Stage 1 Road Safety Audit

S278 Access Works 150 Dwelling Site

Roundstone Lane Angmering

Proposed Alteration of Existing Traffic Calming Feature Roundstone Lane, Angmering Designer's Response to Stage 1 Road Safety Audit

Drawing 22067/104C Proposed Raised Junction

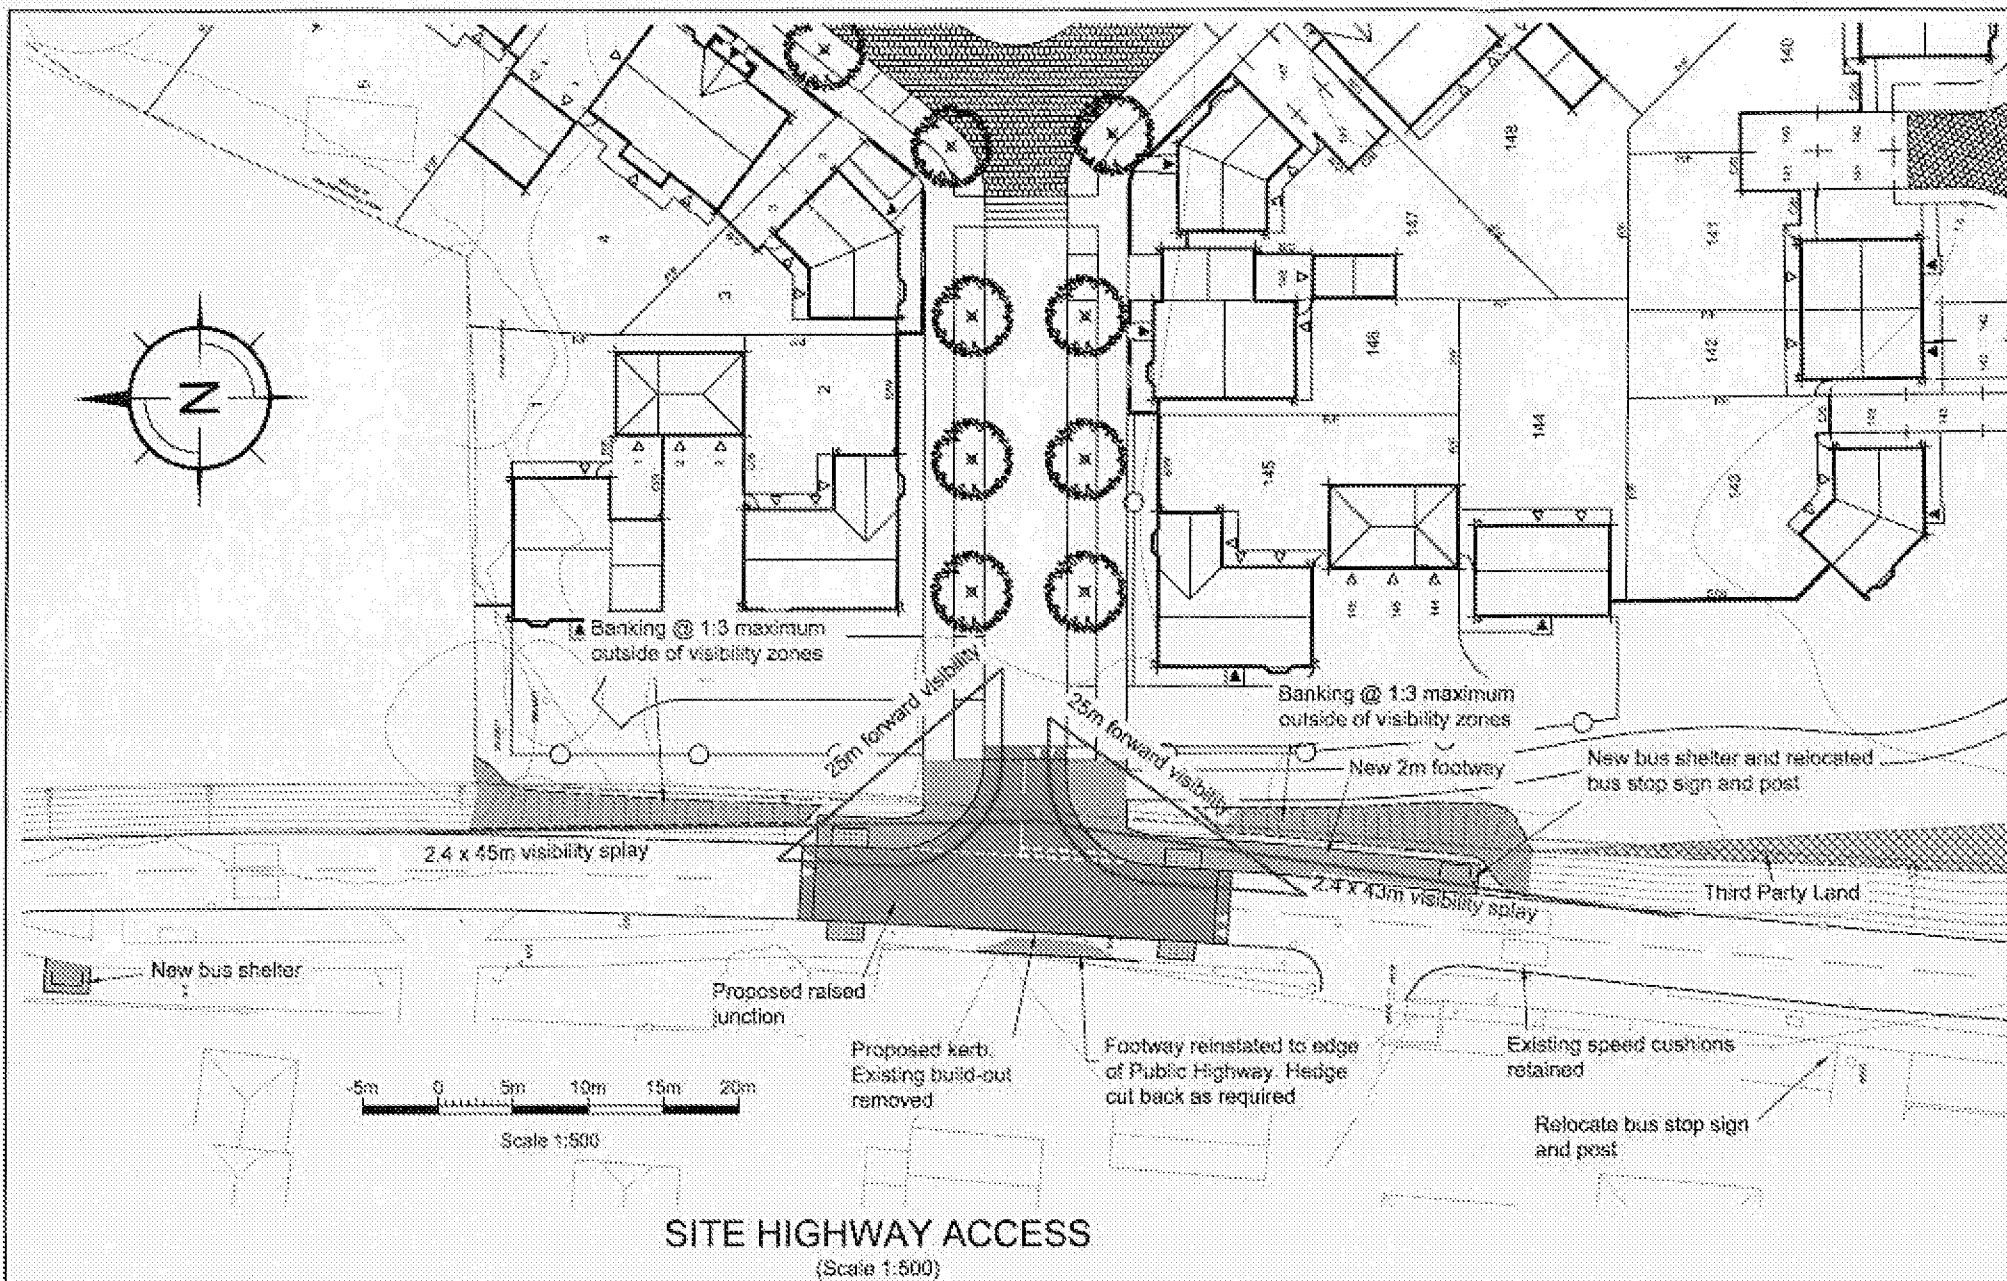
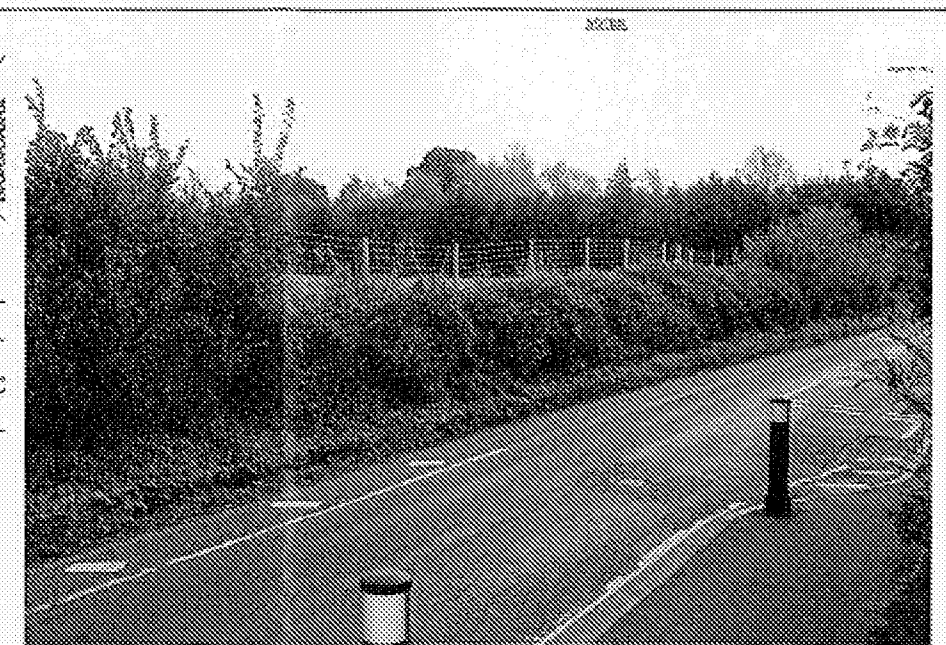
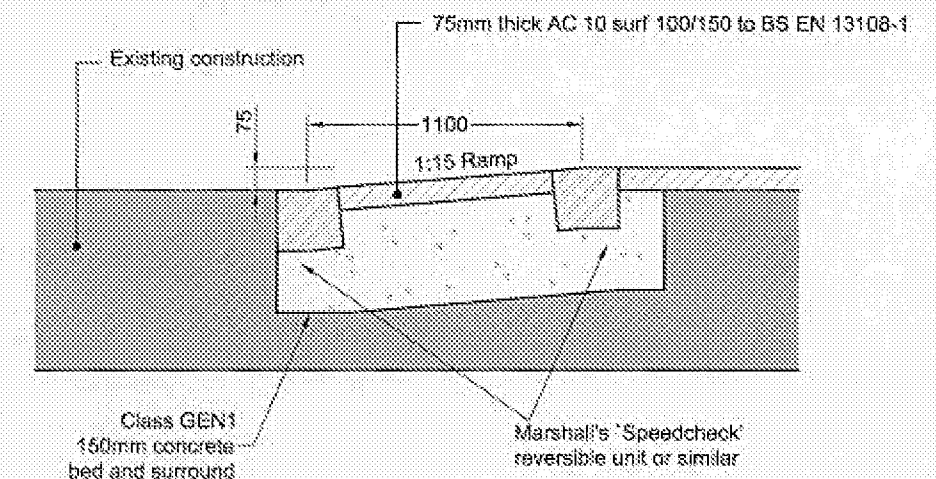
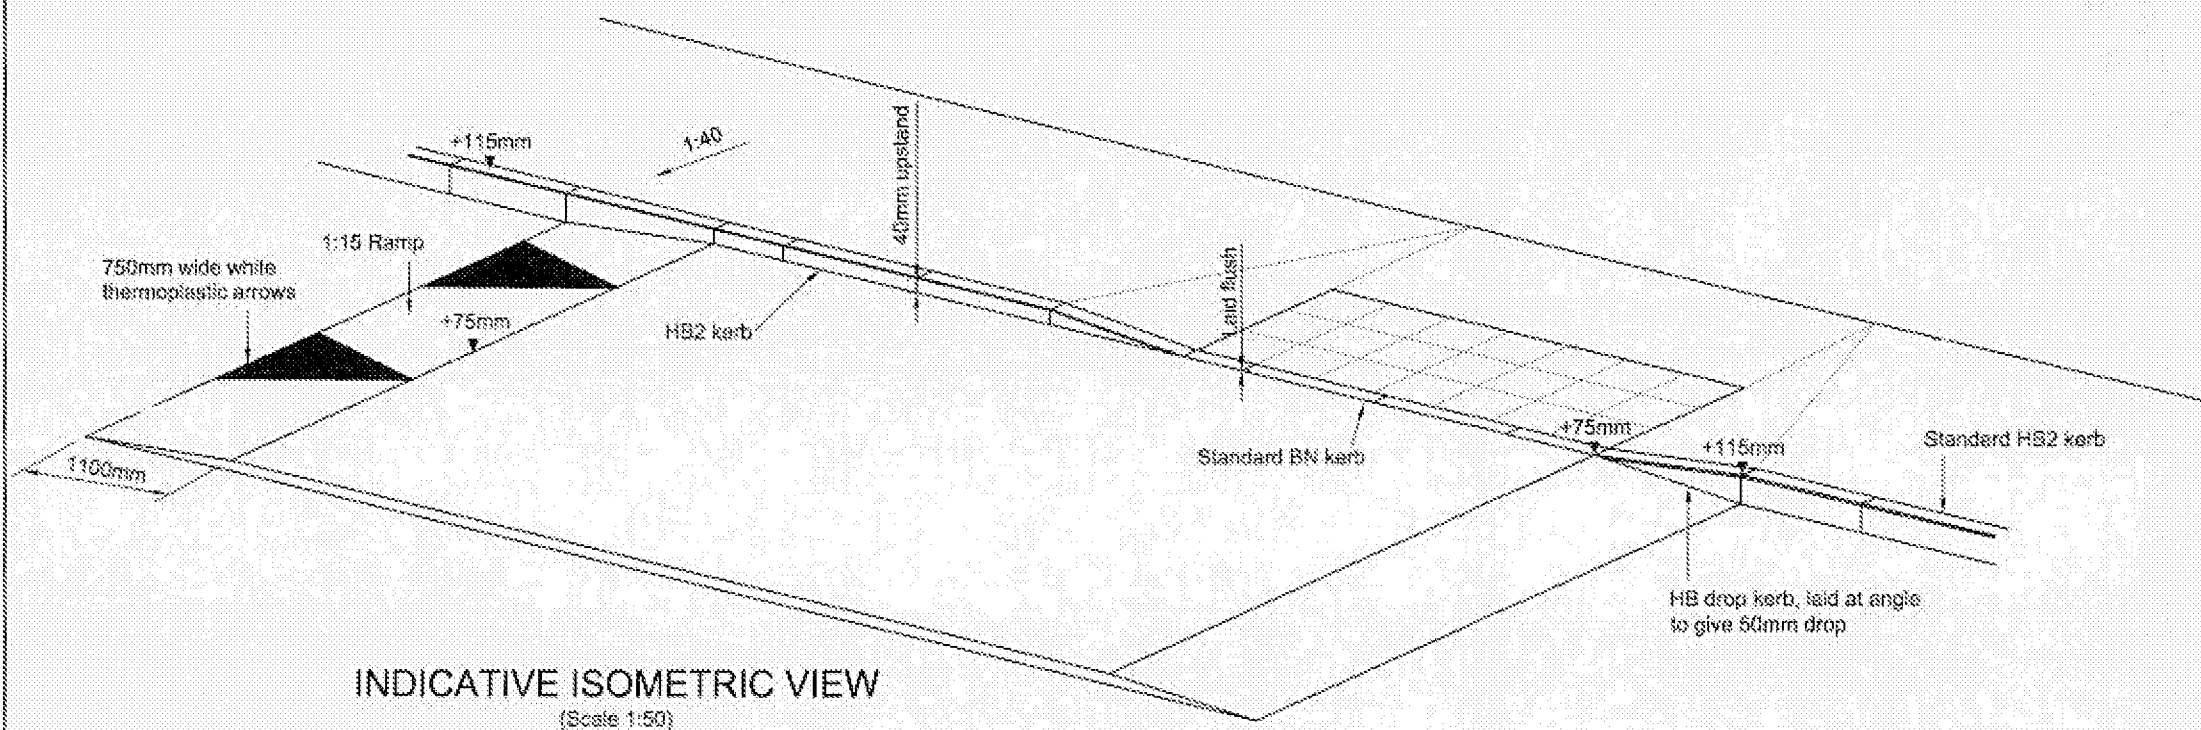
4.1.1 Location: Bus Stop South of proposed access

Summary: Increase in usage of bus stop could lead to pedestrians alighting and walking in the carriageway increasing the risk of pedestrian/vehicle collisions.

Just to the South of the proposed access there is a Bus Stop which serves the southbound bus service. Due to the lack of footway on the East side of Roundstone Lane bus passengers currently wait on the West side and then cross the road to board the bus on the East side. The development is likely to generate increased demand at this bus stop and the current situation may lead to more passengers crossing the road to board the bus or alighting in the carriageway and potentially walking in the road to the new access. This could increase the risk of pedestrian/vehicle conflicts on Roundstone Lane.

Extend the footway south of the development as far as the existing bus stop and move the bus stop flag to the East side of Roundstone Lane on to the new footway. Bus access kerbing should be provided if appropriate.

There is third party land to the south which prevents extending the footway to the bus stop location.

Drawing 22067/104C shows the footway extended as far as possible and the bus stop relocated onto the new eastern footway and will be provided with a shelter and bus access kerbing.

3.1.1 Location: Accesses within external development

Summary: Proposed landscaping may be within sightlines and could increase the risk of failure to give way collisions.

The Highway Access Plan provided (104_B) shows 25m forward visibility splays between drivers entering the development and the first accesses associated with dwellings. The Architects Layout however, shows proposed vegetation within these splays and this could increase the risk of drivers exiting accesses failing to give way to those entering the development.

Ensure the visibility splays are kept clear of any proposed vegetation/landscaping.

Agreed.

All landscaping and vegetation will be removed from within the visibility splays.
